Your Ref: OWPC21495
Our Ref: EG/7/19/PL 17-01-2019
Please ask for:
Stuart Corbey

Demolition of existing detached dwelling & garage & erection of 1 No. dwelling with car port.

26 Downview Road Barnham

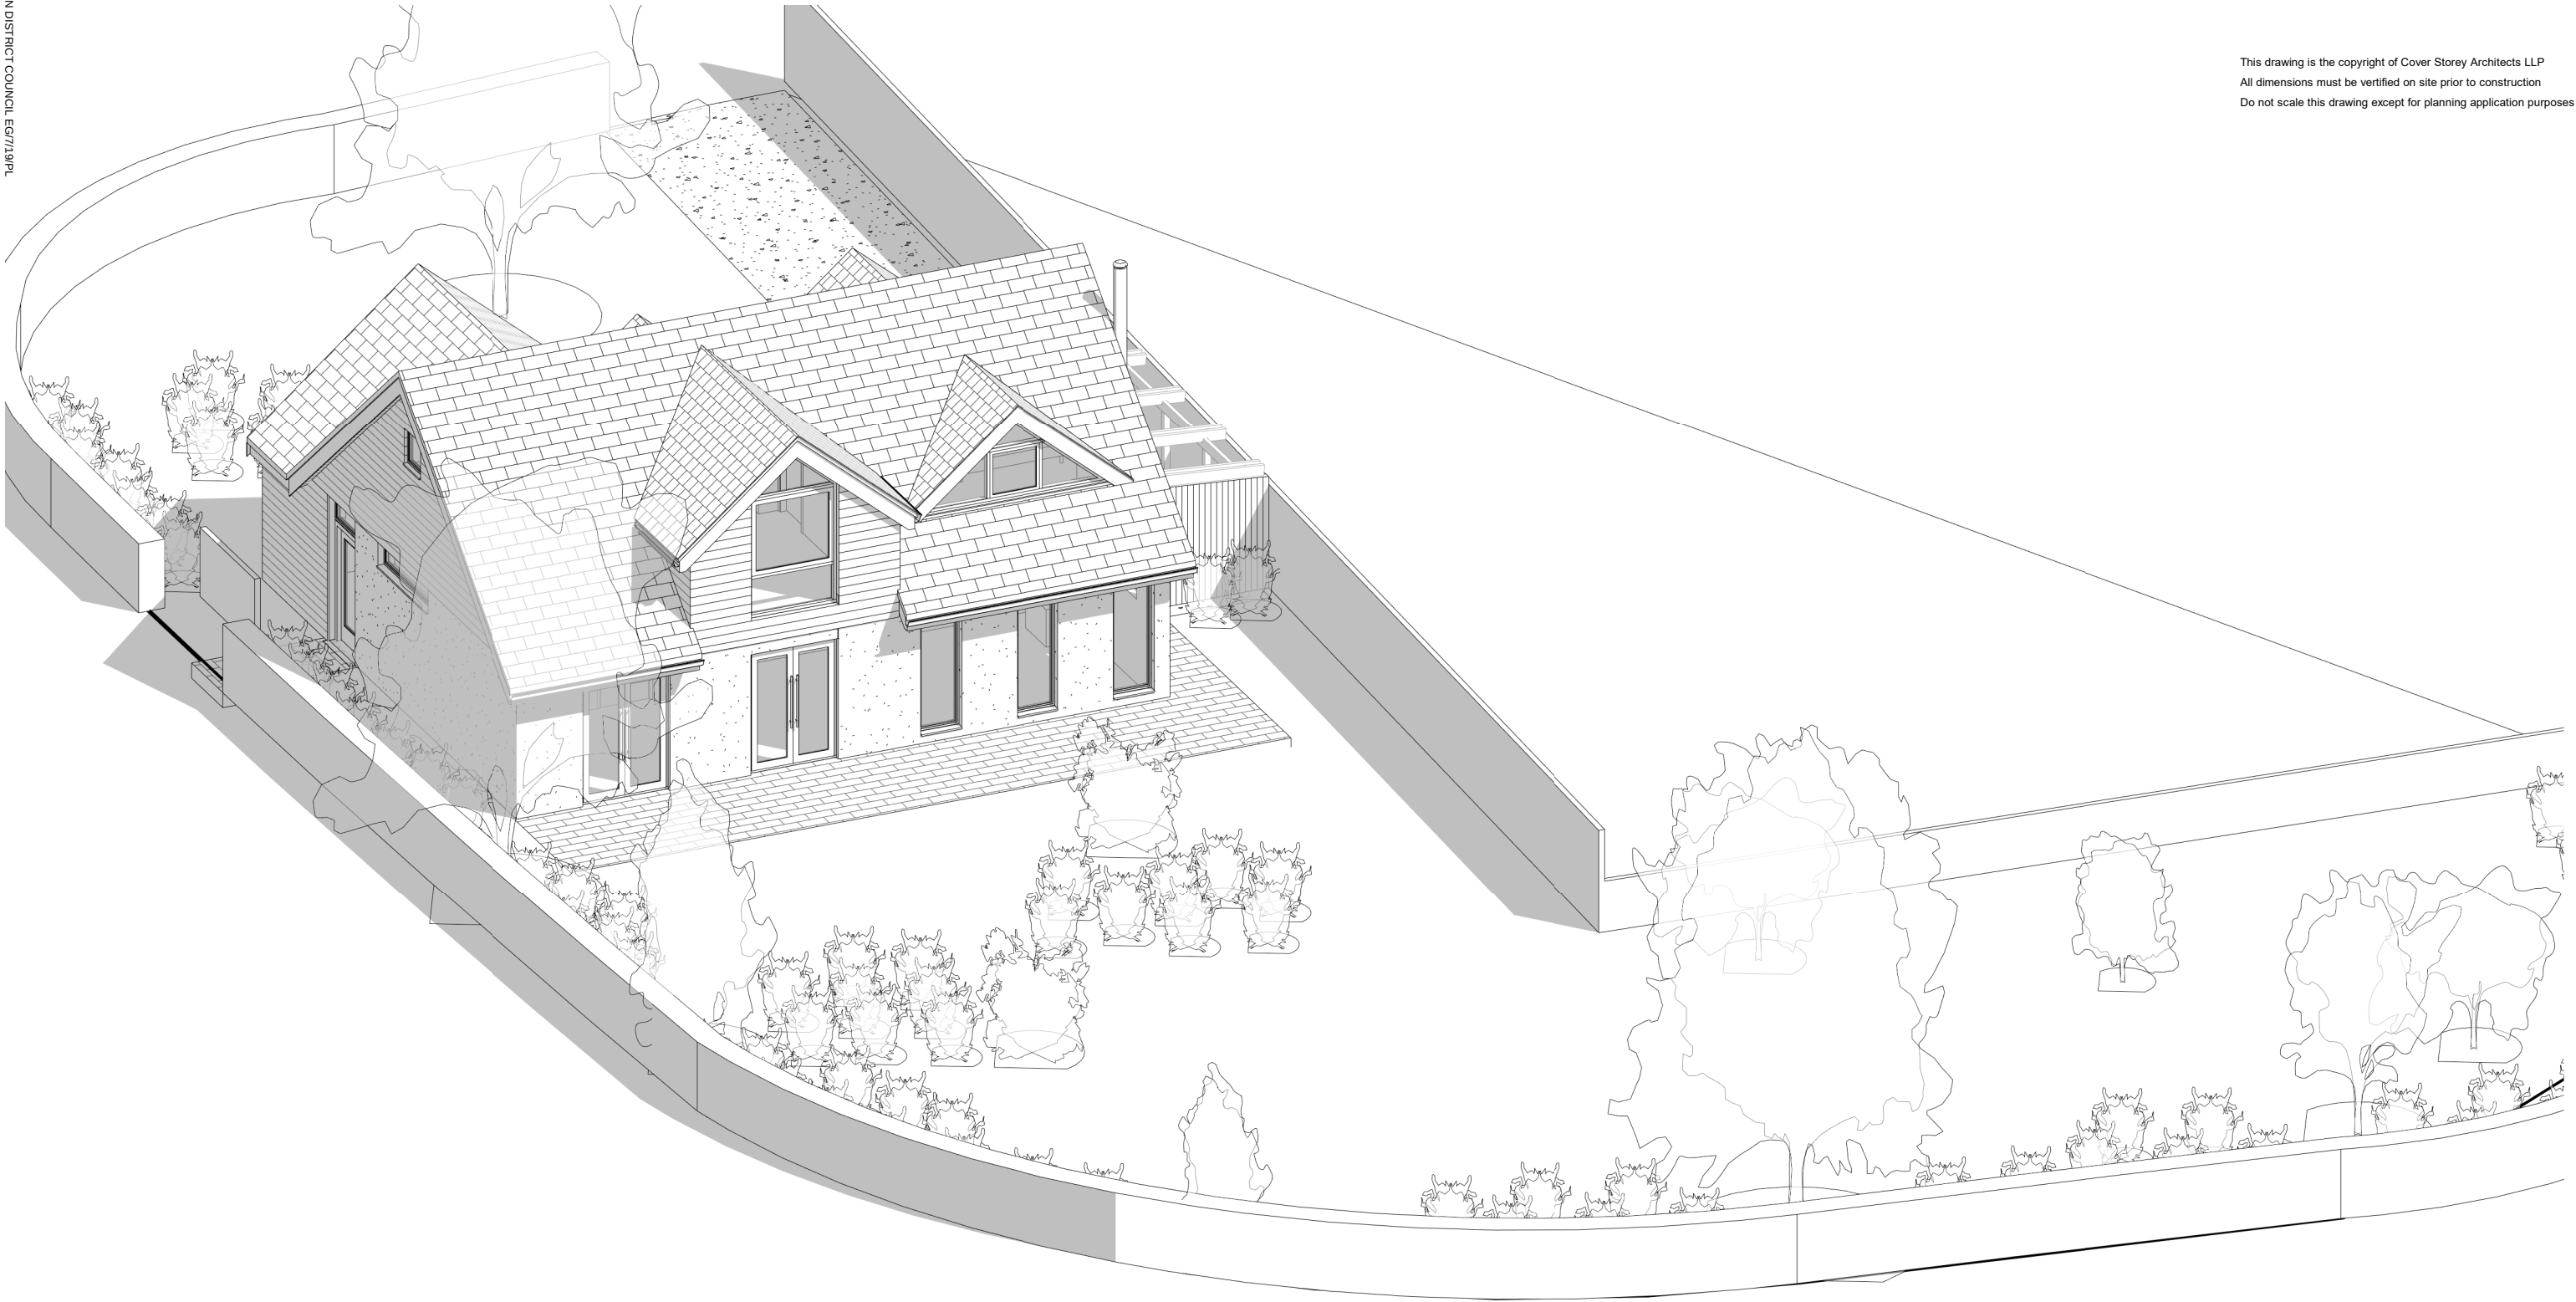
Very concerned about the possibility of the overlooking view from this new development directly into our home at 1 Ewens Gardens. Existing treeline restricts this view currently and also the current dwelling is only one story. With the proposed removal of the existing treeline and the planned west facing dormer window on the first floor this new development will have significant effects on my family's privacy. Any replacement trees will take some years to establish and this changed aspect will have a prolonged impact on our home and may, potentially, affect the resale value of our property.
